Ref 2241.corr.RVBC260619

2241 Winkley Hall Farm, Whalley Road, Hurst Green , BB7 9PN

Application references 3/2026/0094 and 0095

B East Facing Section B
Scale: 1:50

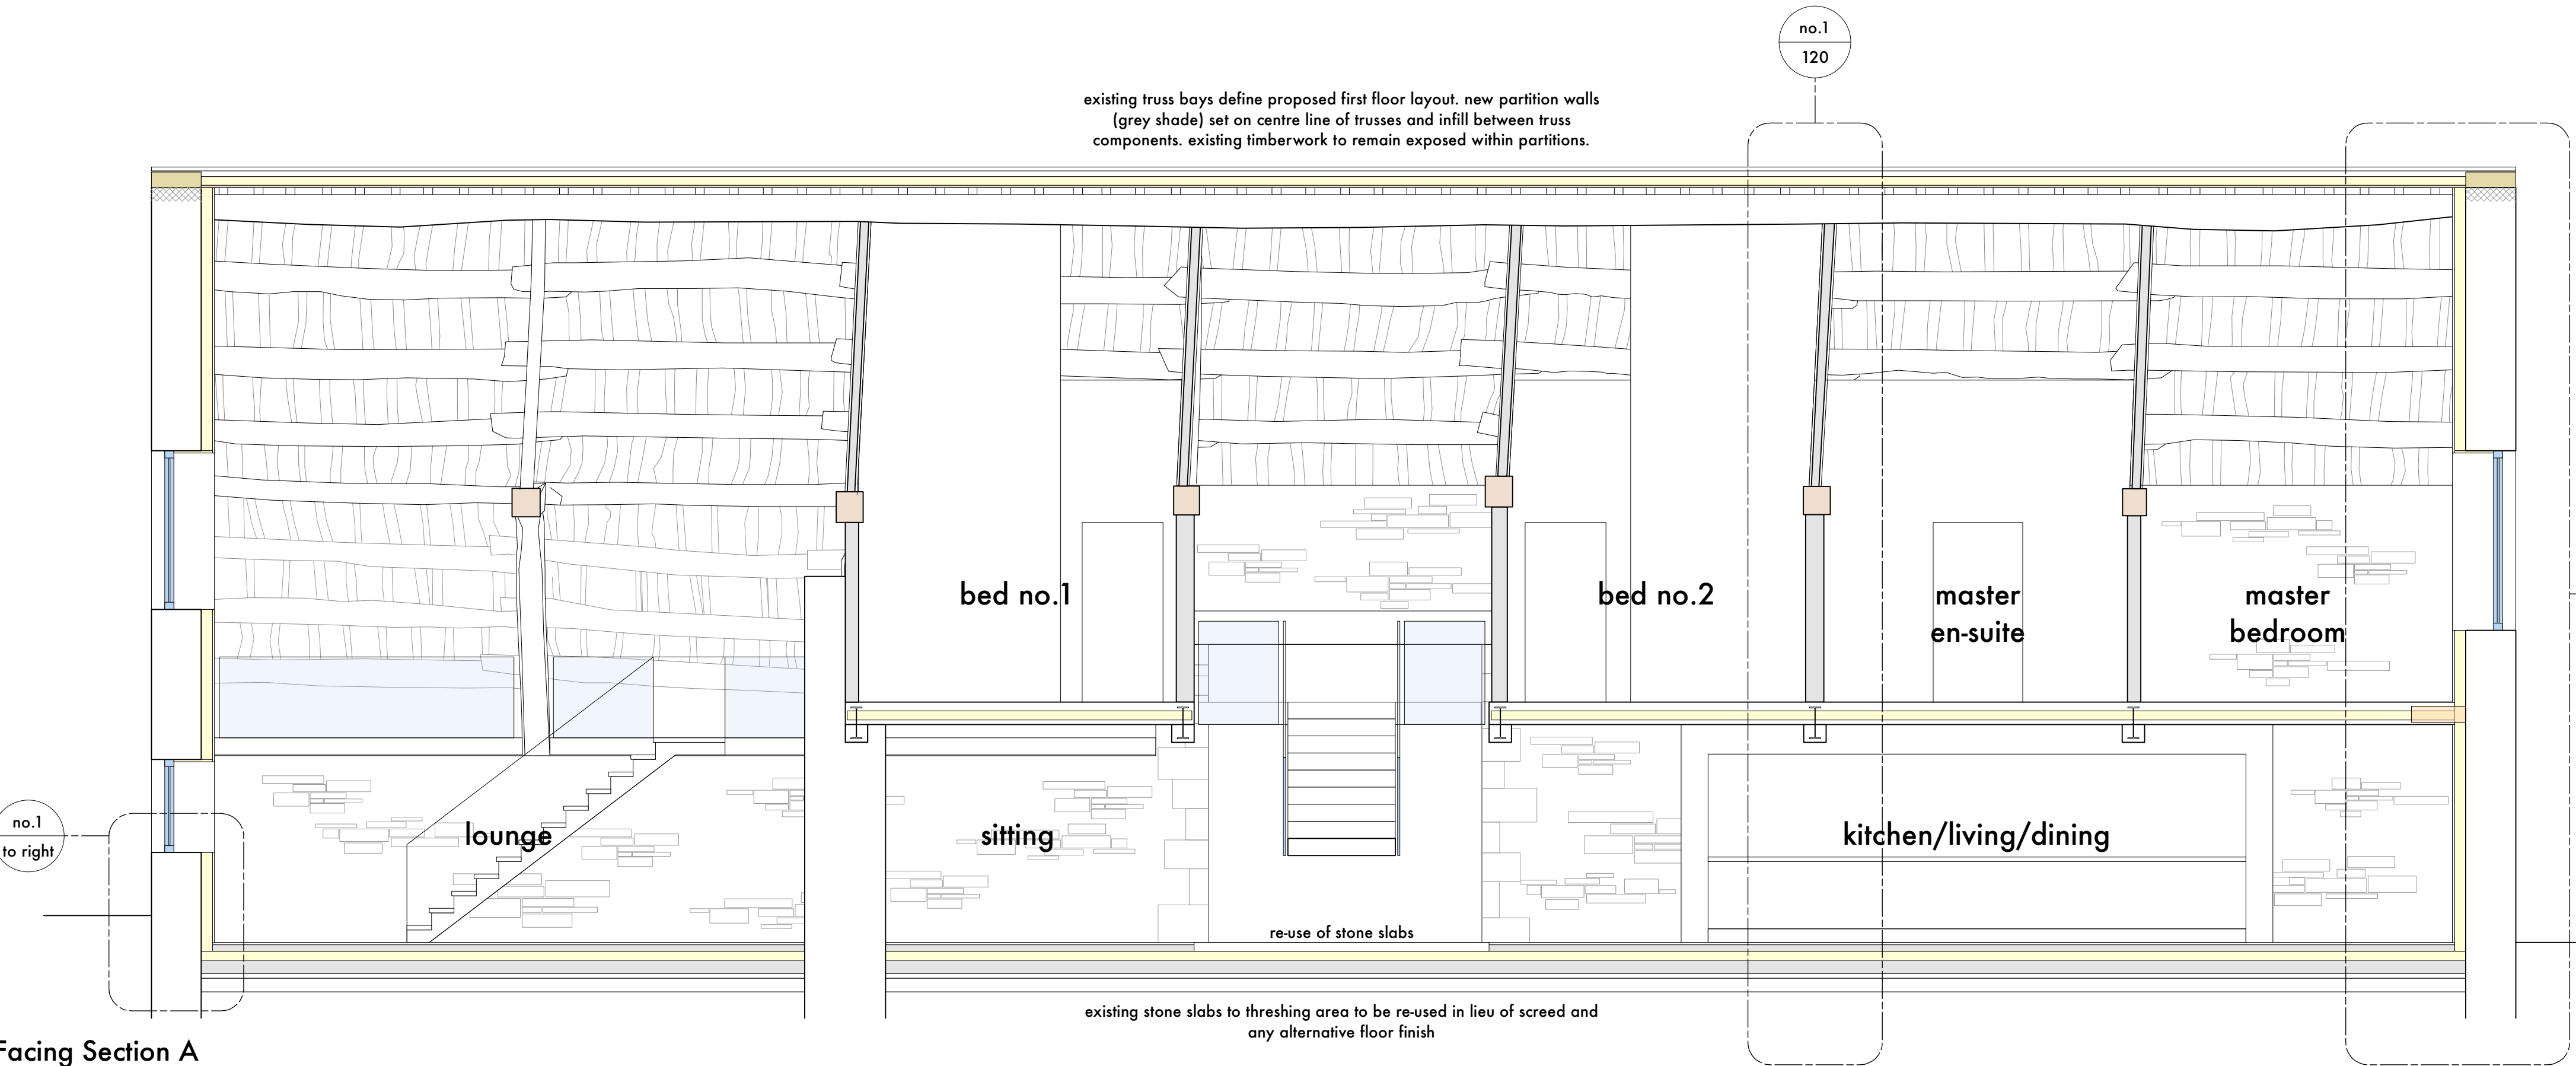
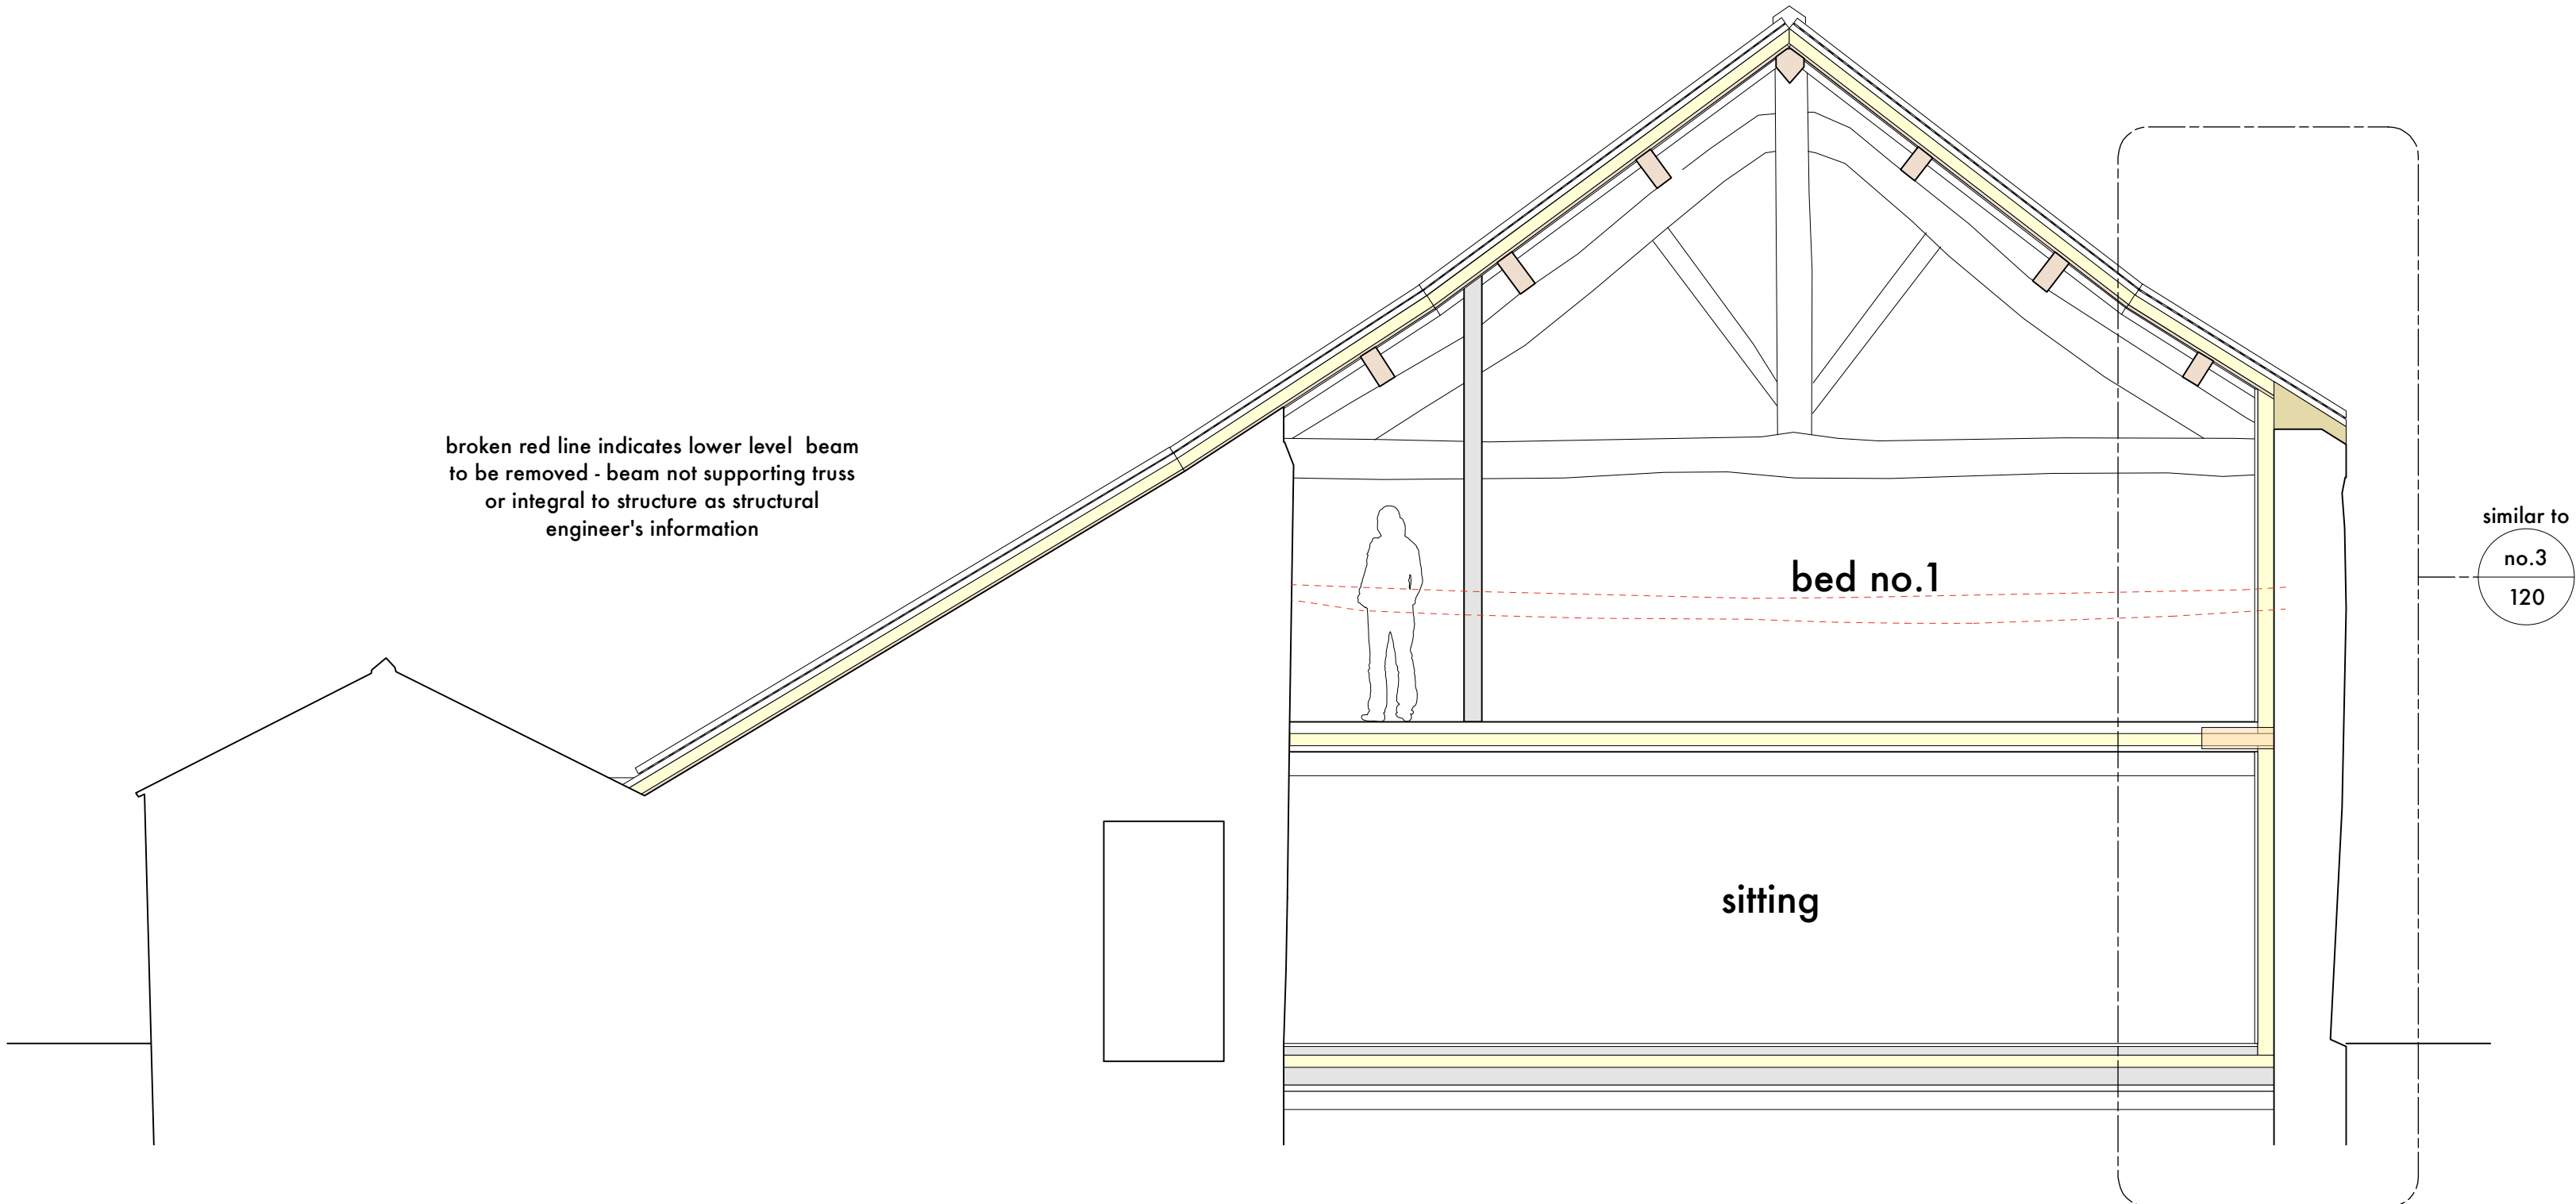
9. De-frassing is to be removed from the revised structural report as part of an alternative repair/treatment strategy.
10. We assume this point related to the low-level beam in the Main Barn – now illustrated on sections B (107 existing & 117 proposed). This beam is not a tie beam and also plays no part in supporting the truss as assumed by Growth Lancs. The beam would need to be removed to accommodate the proposals and provide access to the relocated bed no.1 (to suit point 7) from the main stair. We do not believe omitting a bedroom is an option given the scale of this barn. Providing an alternative access to the bedroom via the study/library deck has also not been considered due to restricted headroom.
